## Environmental Health Consultation Response

<b>To</b>	Mr S Davis
<b>Date</b>	31-08-2025
<b>Planning Ref</b>	BN/97/25/PL
<b>Site Description</b>	Street Record Walberton West Sussex
<b>Date of Application</b>	2025-08-28 00:00:00
<b>Category</b>	Application
<b>Recommendation</b>	<del>No Objection</del> <b>No Objection – with conditions</b> <del>Objection</del> <del>Holding Objection</del>

I have considered the above application, and as with the previous application, I have several areas of concern.

As Proposed Site Plan

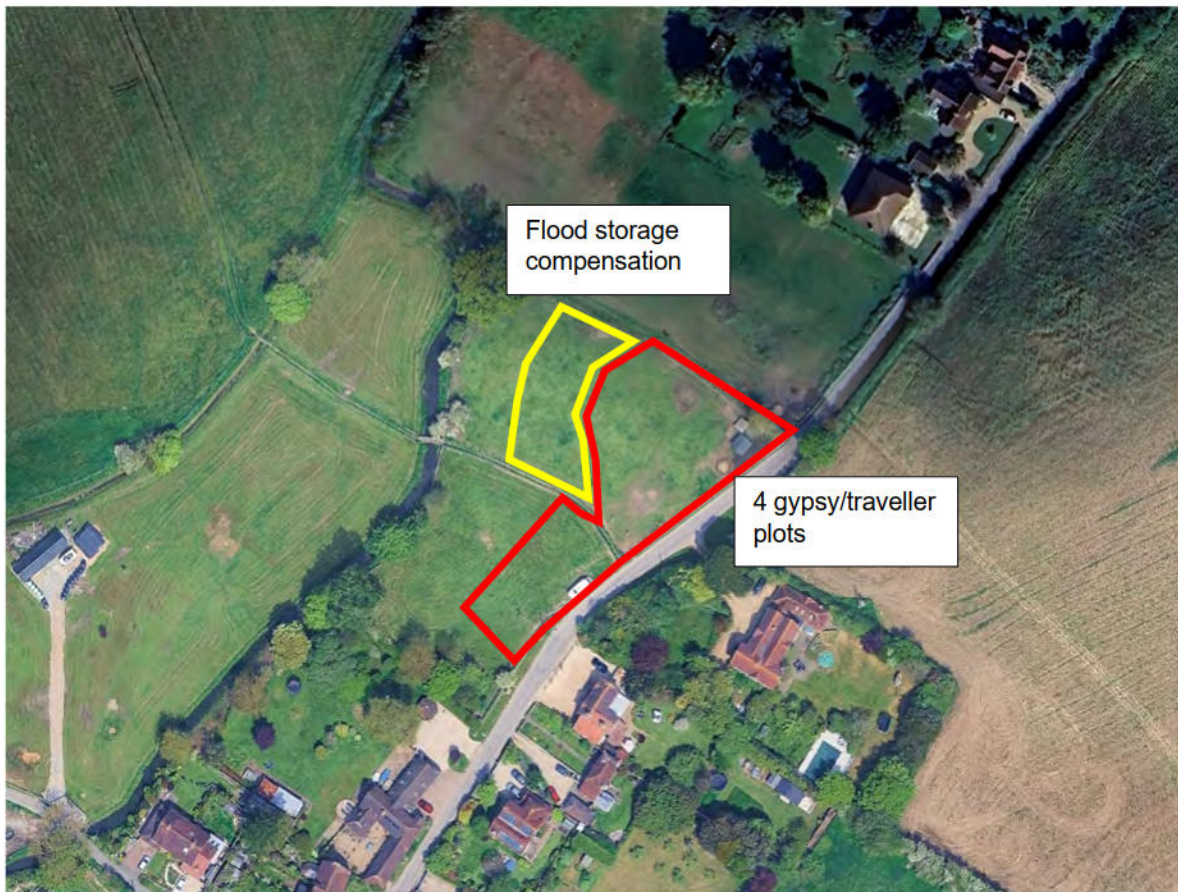
The application is for 4 No. permanent private gypsy plots, however the application shows 4 static sites and day rooms, my concern is that the proposed development will be home more than just the occupants of the proposed 4 permanent plots, and I am concerned about the potential impact this over intensification of the site will have on the local amenity.

The application still does not mention how the site will be powered or how the units will be heated so the impact of any plant or machinery cannot be assessed.

The lighting impact from the proposed development has also not been considered and neither has the risk from land contamination that can occur with old agricultural land.

No more than

**4**

caravans shall be stationed on the land at any time.
